SEAS DEADLINE 6 RESPONSE to APPLICANTS's SUBMISSIONS
SINCE DEADLINE 5, ISH3, Action Points and ExQ3
LANDSCAPE & VISUAL and CULTURAL HERITAGE

PINS Ref: EN020026
DEADLINE 6: APRIL 13, 2026

RE: SEAS Response to Applicant's Submissions since Deadline 5, ISH3, Action Points and ExQ3 – Landscape & Visual and Cultural Heritage

EN020026 SEA LINK DCO – DL6: RESPONSE BY NICHOLAS BRIDGES

**Figure 7. Sea Link 2023-10 PEIR Volume 3 Part 2 Chapter 2 Figures A, page 9:**  
 REPRESENTATIVE VIEWPOINT LOCATIONS AND SCREENED ZONE OF THEORETICAL VISIBILITY - PROPOSED SAXMUNDHAM CONVERTER STATION AND SPR FRISTON SUBSTATION (OPTION 2)

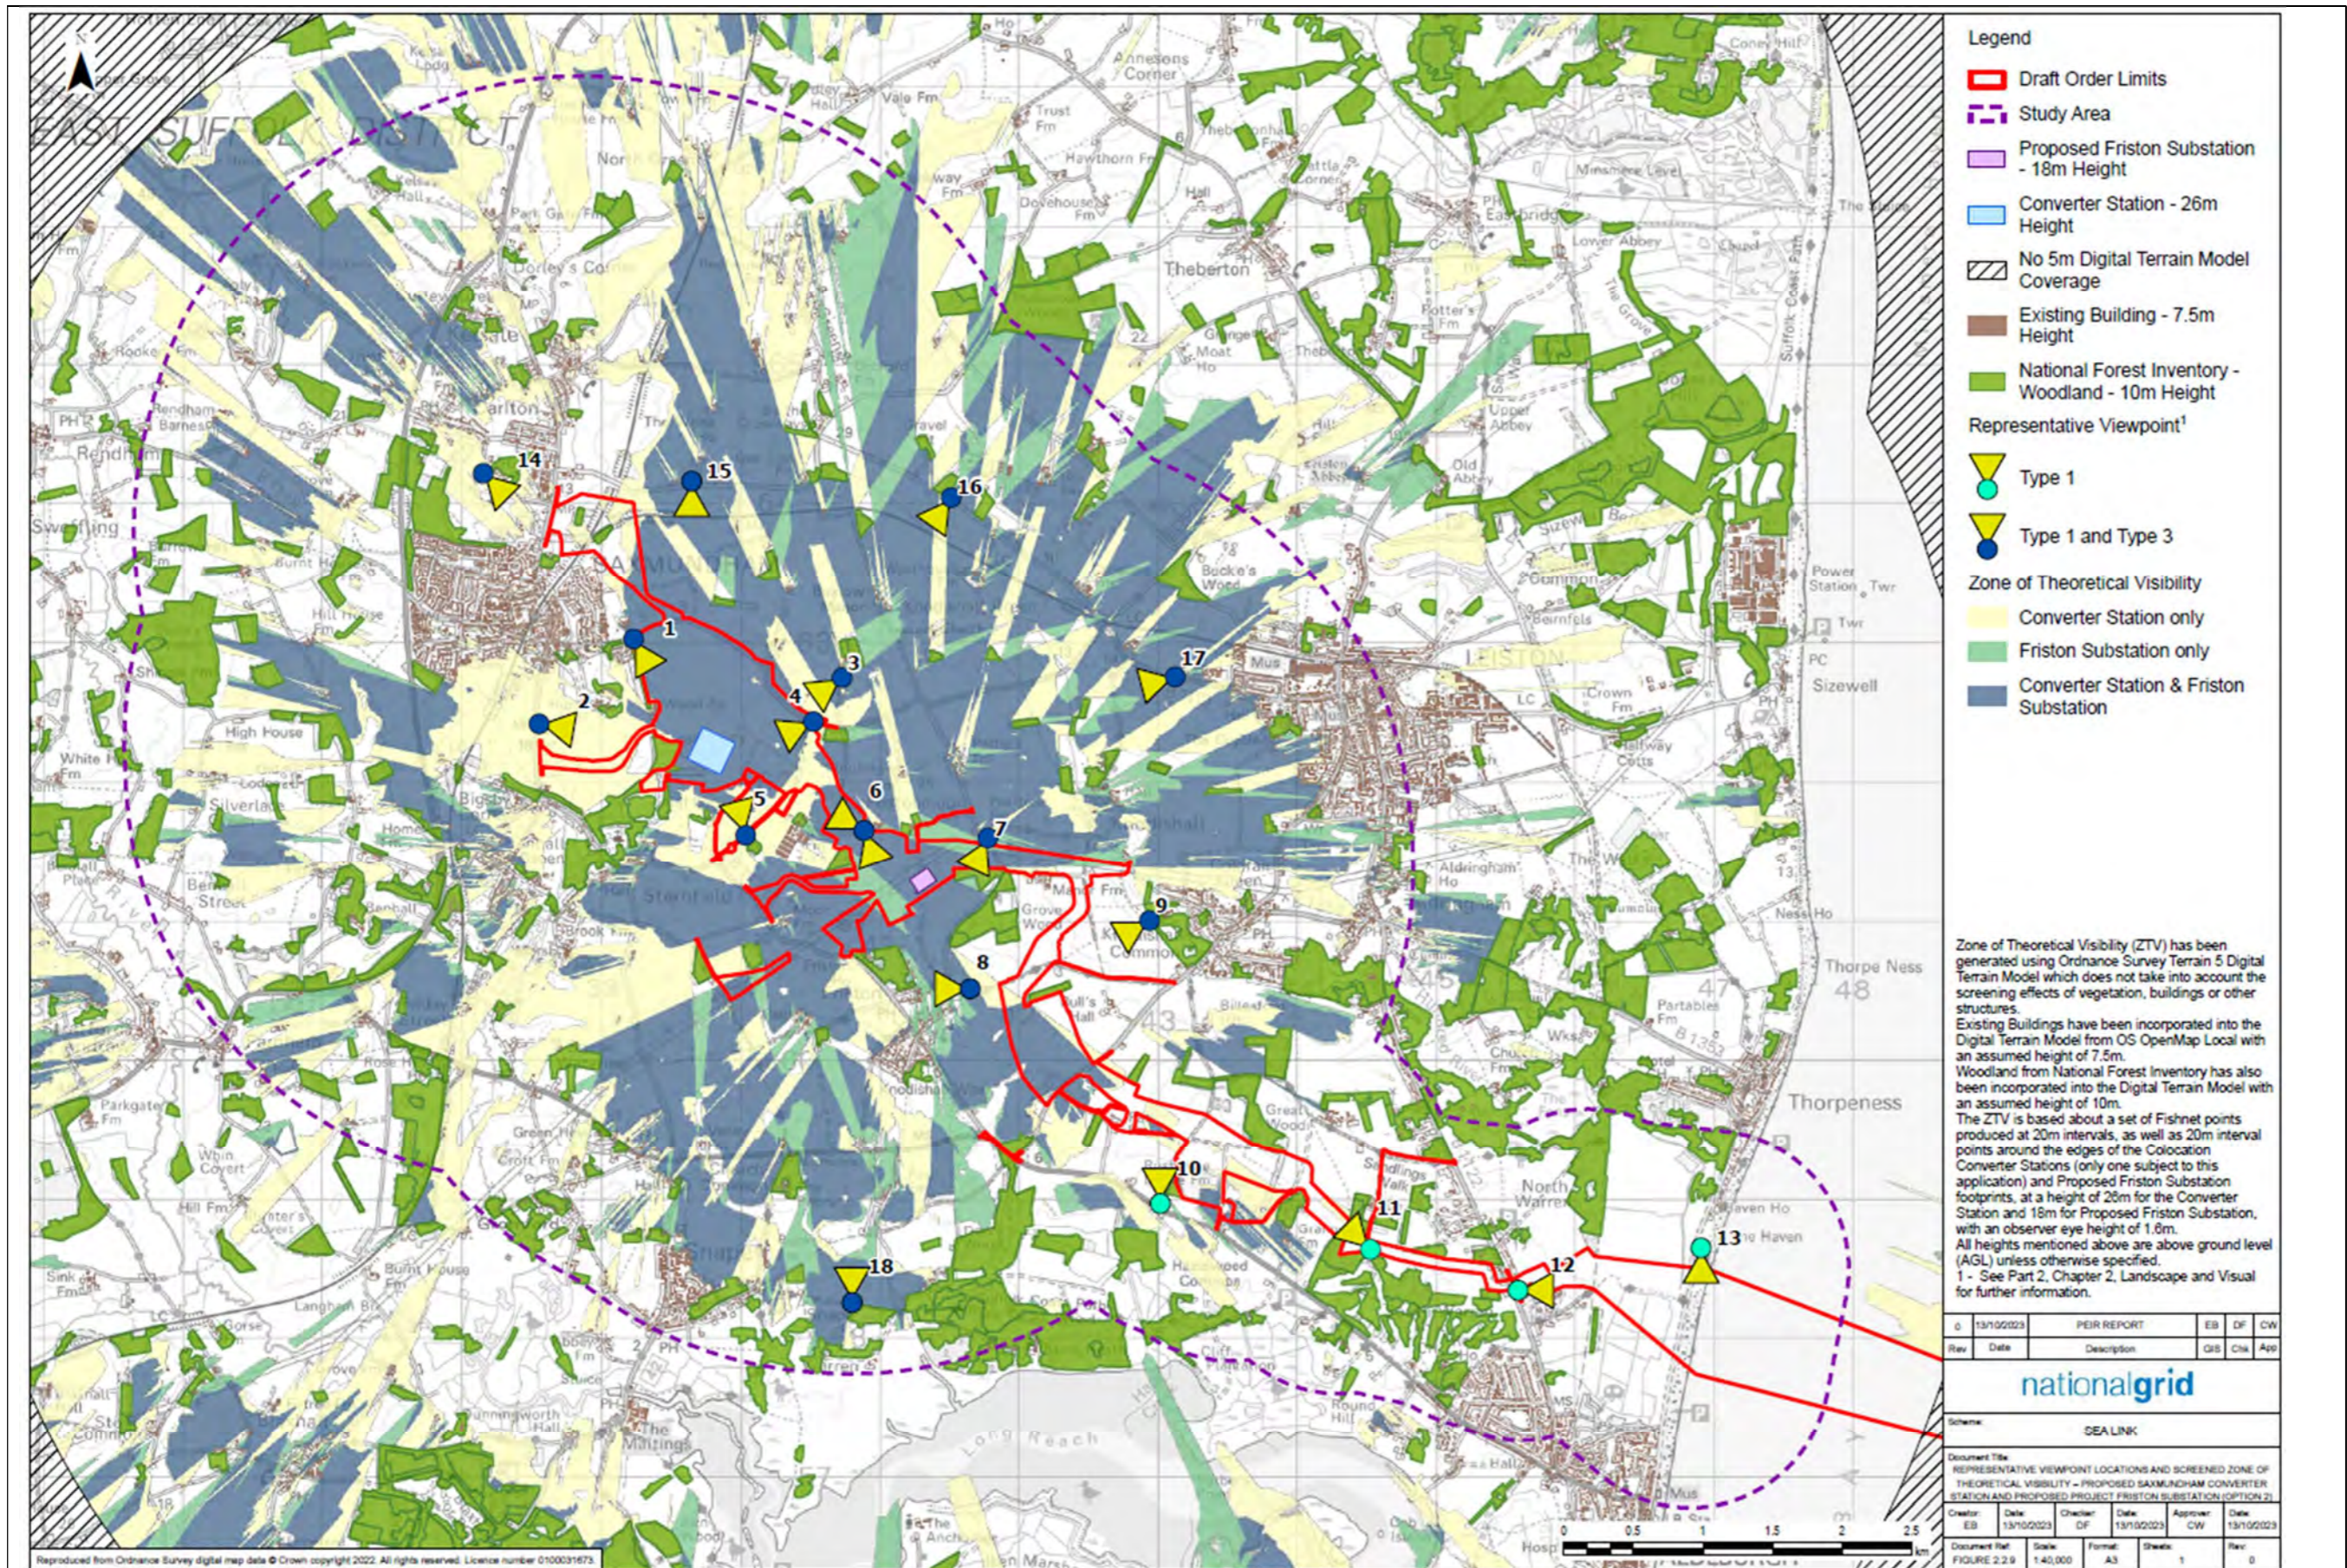
2.9. The ZTVs of the two Friston projects and Sea Link's PEIR have a similar pattern of visibility around their projects (see **Figures 1 to 11** below). Sea Link includes the National Grid substation at Friston which each of EA1N and EA2 also included. All Projects were modelled using OS contours, woodland and buildings at a generic height. Observer heights were a little higher for EA1N and EA2. The two Friston substations used the same parameter model as Sea Link.

2.11. The **first question** is: why are the PEIR and DCO plans so completely different? Were the heights in the model changed? Were the shadowing criteria altered? Which is correct? If the DCO is correct, were the EA1N and EA2 ZTVs incorrect? These are simple technical points which can be explained easily.

2.12. The **second question** is: With the majority of the ZTV plans showing extensive visibility of both Friston substations (18m above ground level) and Sea Link (26m above ground level) on the south side of the Alde estuary, at high tide mark and on the 20m ridge above, why was the information on these plans not followed or commented upon?

**Figure 13. Sea Link EN020026-000339-6.4.2.1 ES Figures Suffolk Landscape and Visual Part 1 of 7, page 15**  
 REPRESENTATIVE VIEWPOINT LOCATIONS AND SCREENED ZONE OF THEORETICAL VISIBILITY - SEA LINK AND FRISTON SCENARIO 2

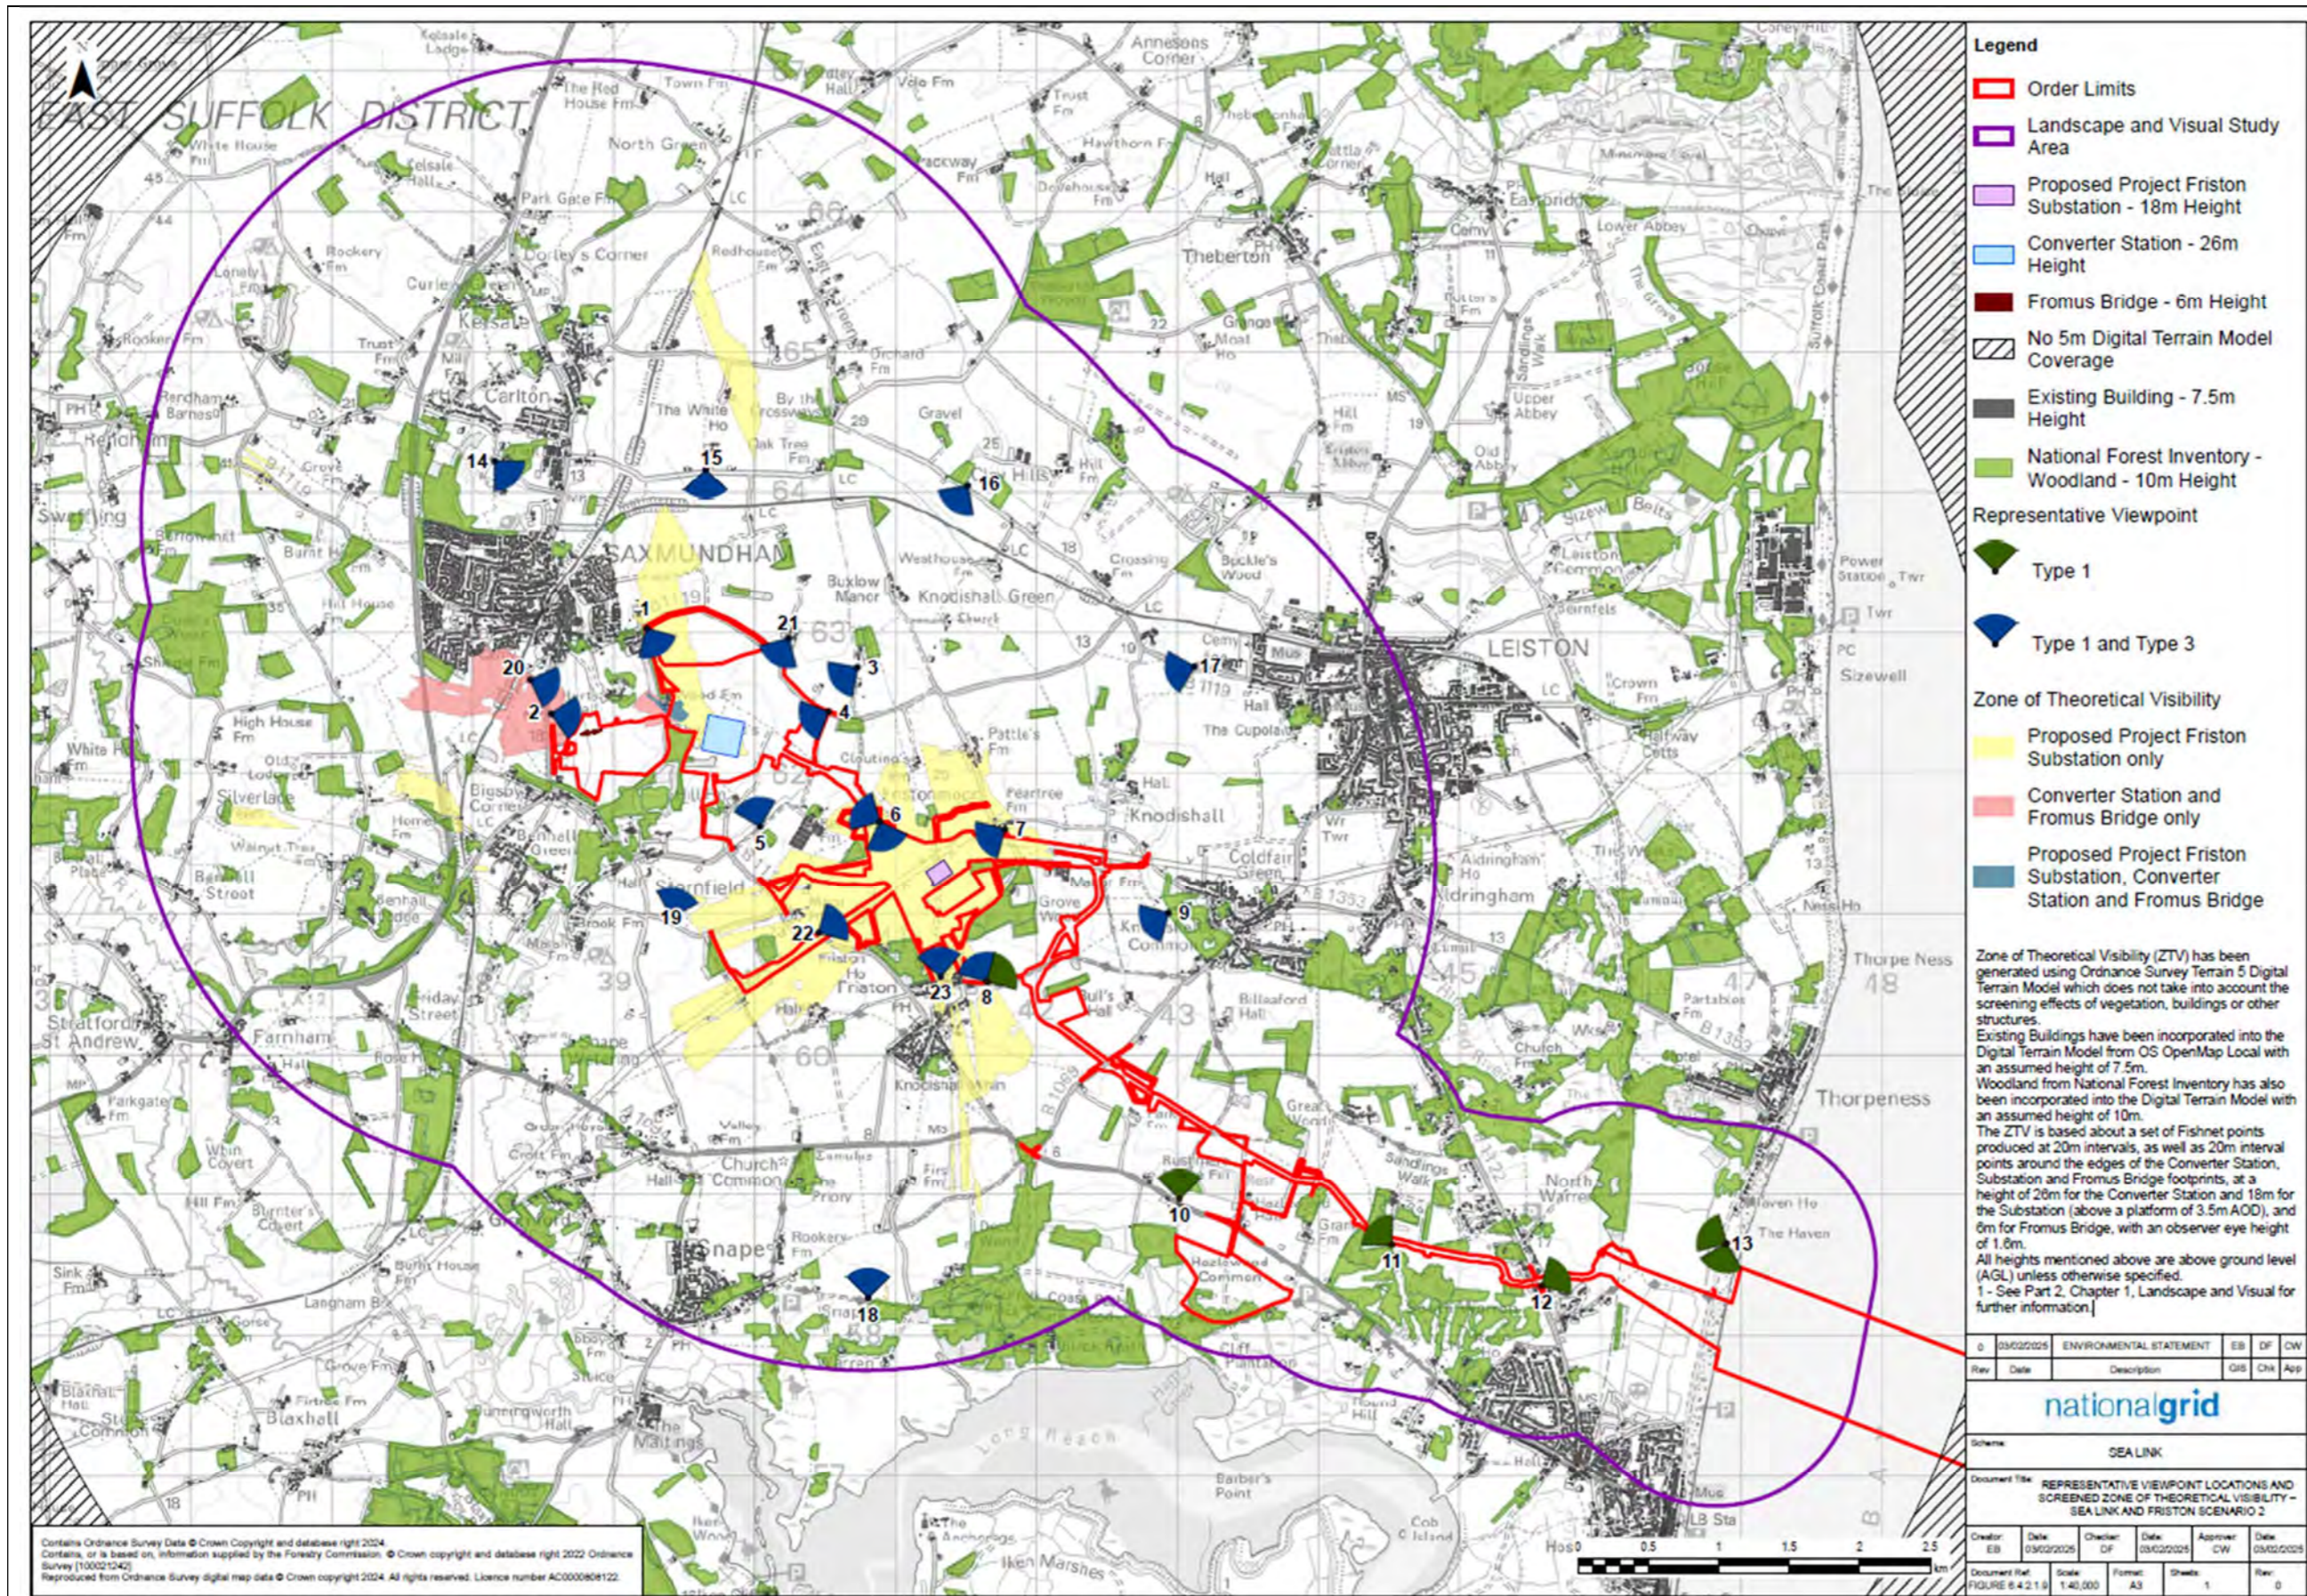
2.10. The 'shadow' patterns illustrate the 'shading' effects of woodland and buildings. The ZTV plans of the same proposed volumetric parameters (**Figures 12 to 17** below) show far less visibility than its PEIR ZTV plans. The accompanying textual details of the model's constraints are exactly the same (see the schedule below).

- 3.1. The submitted DCO ZTV plans should be reviewed for their accuracy.
- 3.2. If they are correct, the applicant must explain why the PEIR was so different
